## Drax Re-Power - Examining Authority's Further Written Questions

The following table sets out the Examining Authority (ExA)'s Written Questions and requests in relation to the Drax Re-Power project.

Figure 1.1 - Extent of Mitigation Covering a 1 km Radius from the Proposed Scheme

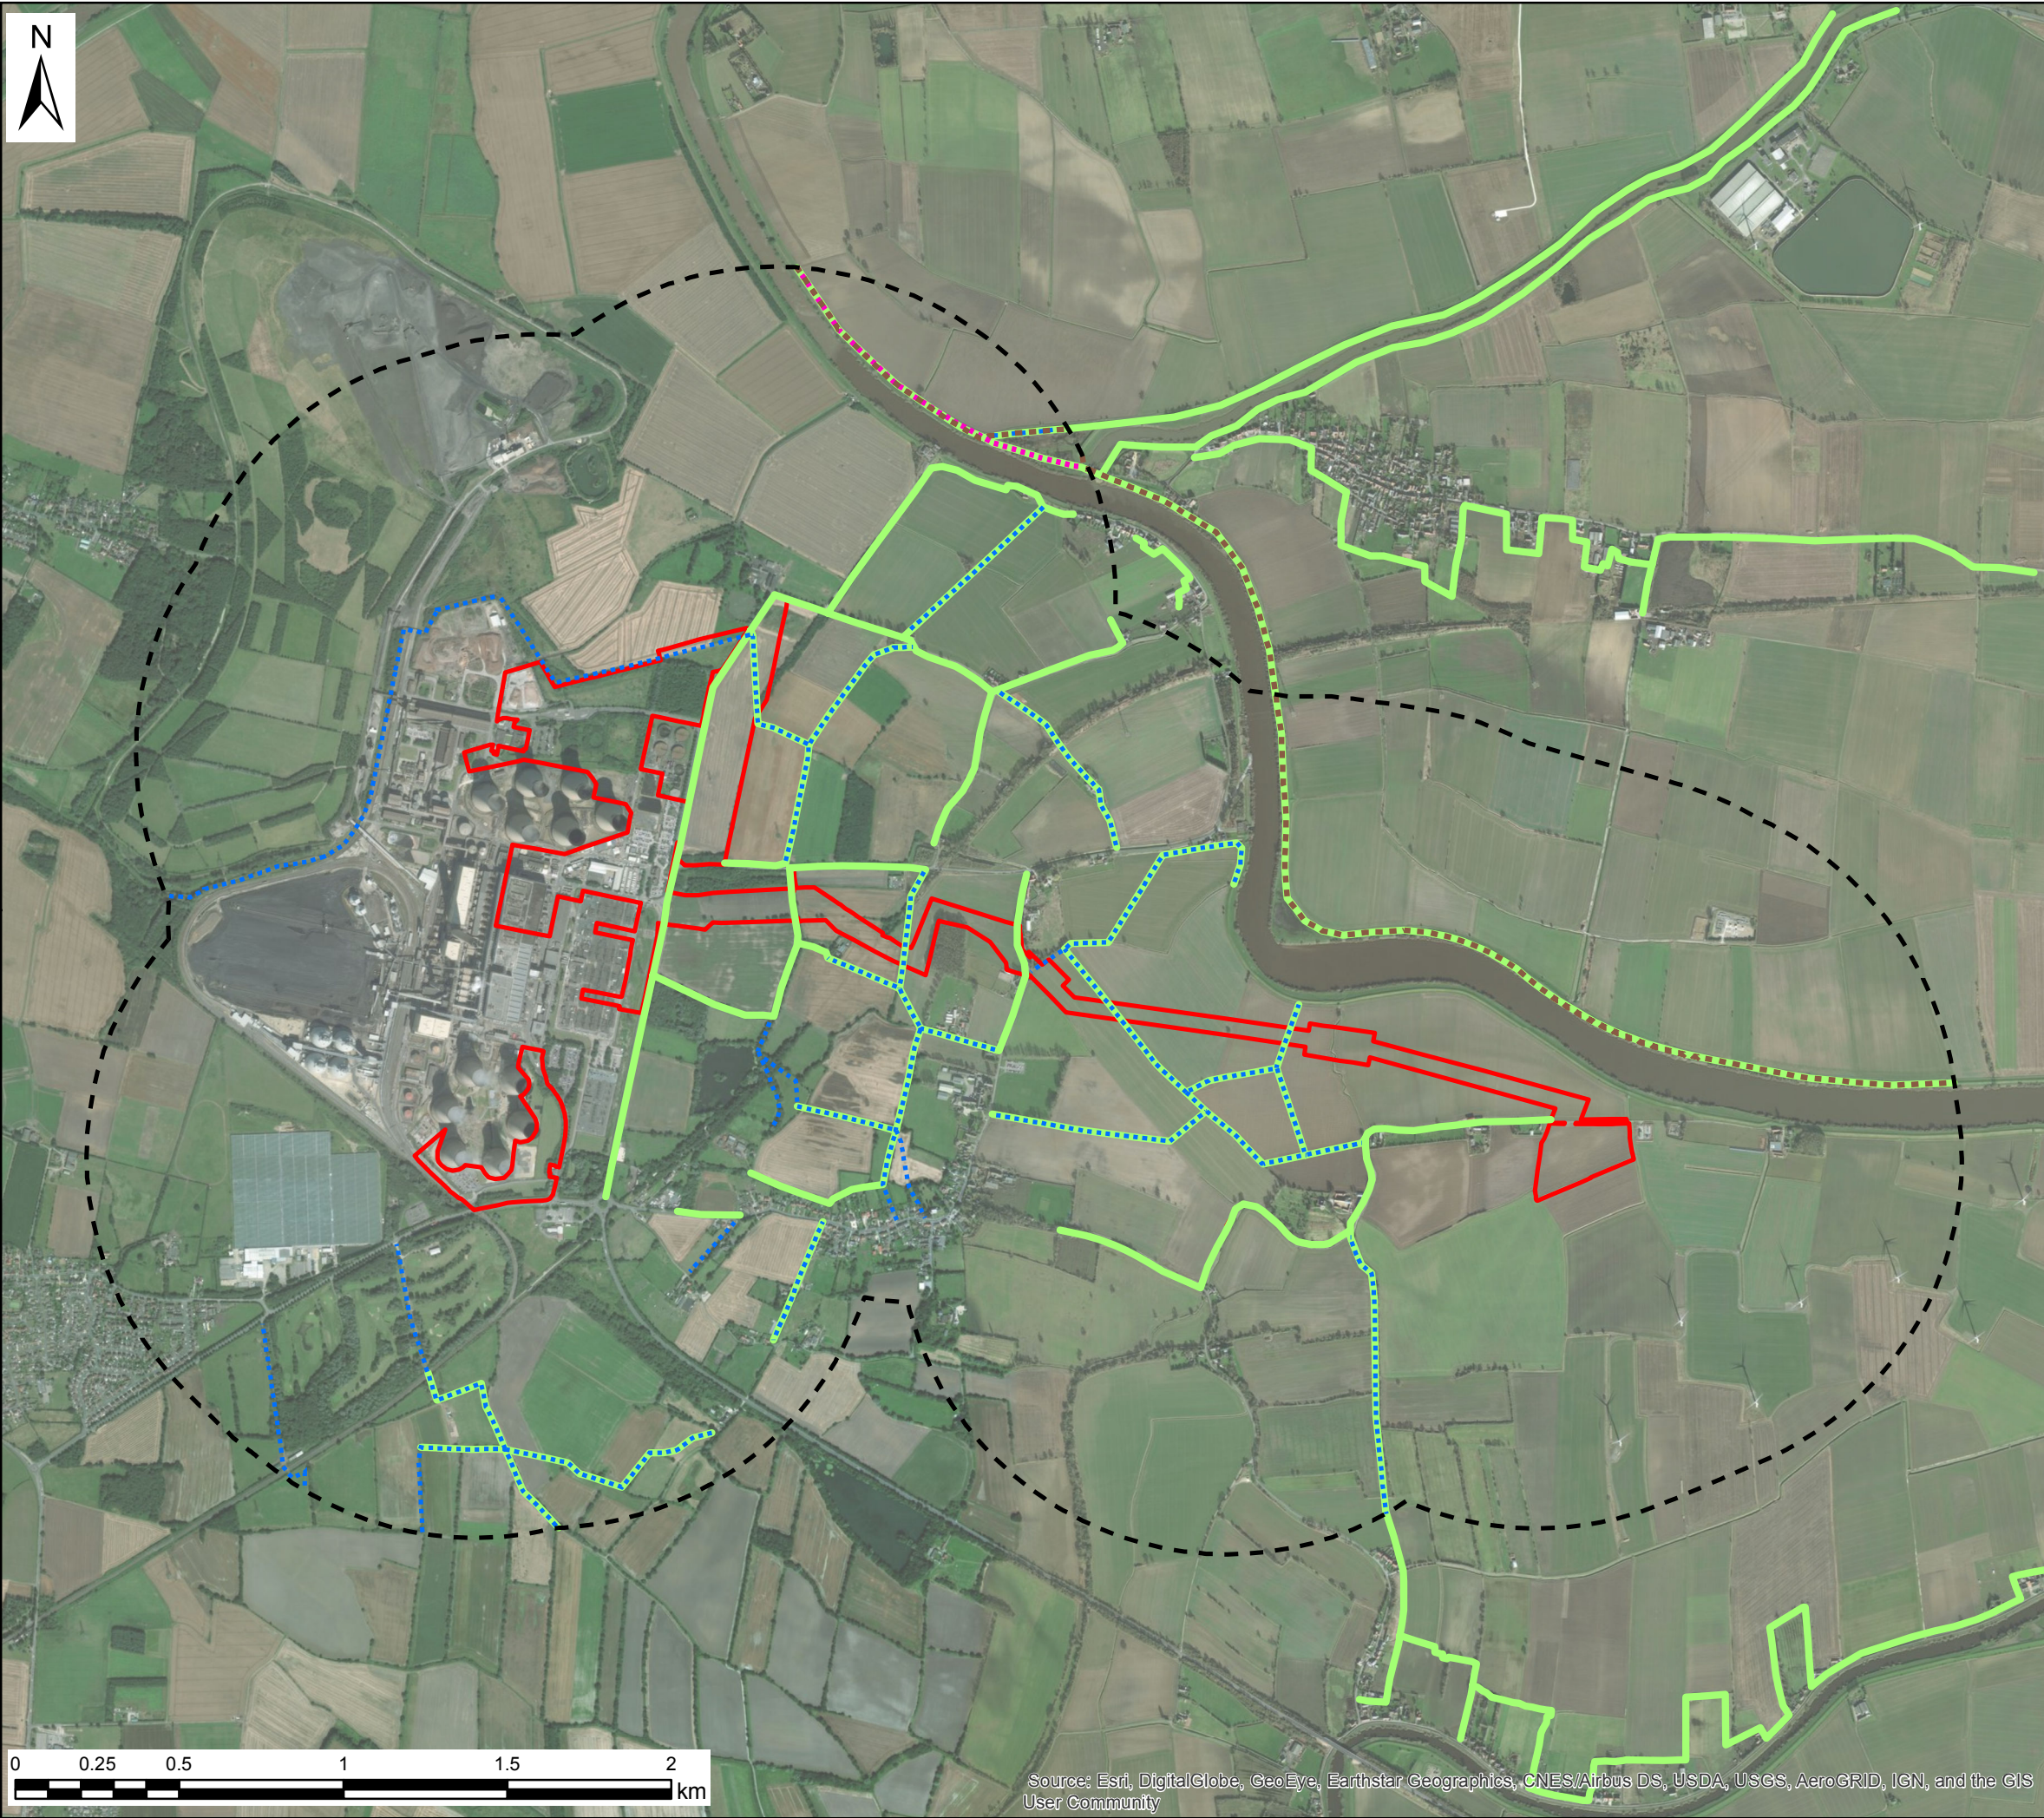
LV 2.3	<p><i>Outline Landscape and Biodiversity Strategy – Mitigation</i></p> <p><b>The Applicant</b></p>	<p>Paragraph 3.16.13 of the draft SoCG with NYCC and SDC [REP4-008] states that the Applicant does not agree with the contents, observations, conclusions and recommendations of NYCC’s D4 submission entitled Drax Re-Power Off-Site Mitigation Strategy [REP4-016].</p> <ul style="list-style-type: none"> <li>i. Set out the main concerns with the submission in terms of the scope of its recommendations, and the proposed financial contribution.</li> <li>ii. Explain how it can be revised to address concerns.</li> </ul>
LV 2.4	<p><i>Revised Viewpoints and Additional Photomontages</i></p>	<p>The Applicant submitted revised Viewpoints and Additional Photomontage as part of its D5 submissions [REP5-017]. However:</p> <ul style="list-style-type: none"> <li>i. Figures 1.1 and 1.4 do not have labels for the photomontage locations; these</li> </ul>

<b>The Applicant</b>	<p>have to be referenced from previously submitted documents. Provide a revised version of the Figures with the photomontage locations labelled on the Figures.</p> <p>ii. Section 4.1.9 states that new information on site topography has been provided, such that although the stacks associated with Units X and Y would increase in height by up to 3m, the difference in height between the stacks and the existing cooling towers would remain the same. Confirm that the correct topographical information has been used in the construction of all of the photomontages and that all of the submitted photomontages are accurate representations.</p> <p>iii. Sections 4.2.3 and 4.3.2; confirm which character area or viewpoints are referred to in the statements "...G / given the oblique angle from which the stacks would be viewed..." or otherwise clarify the statement.</p>
--	----------------------	---
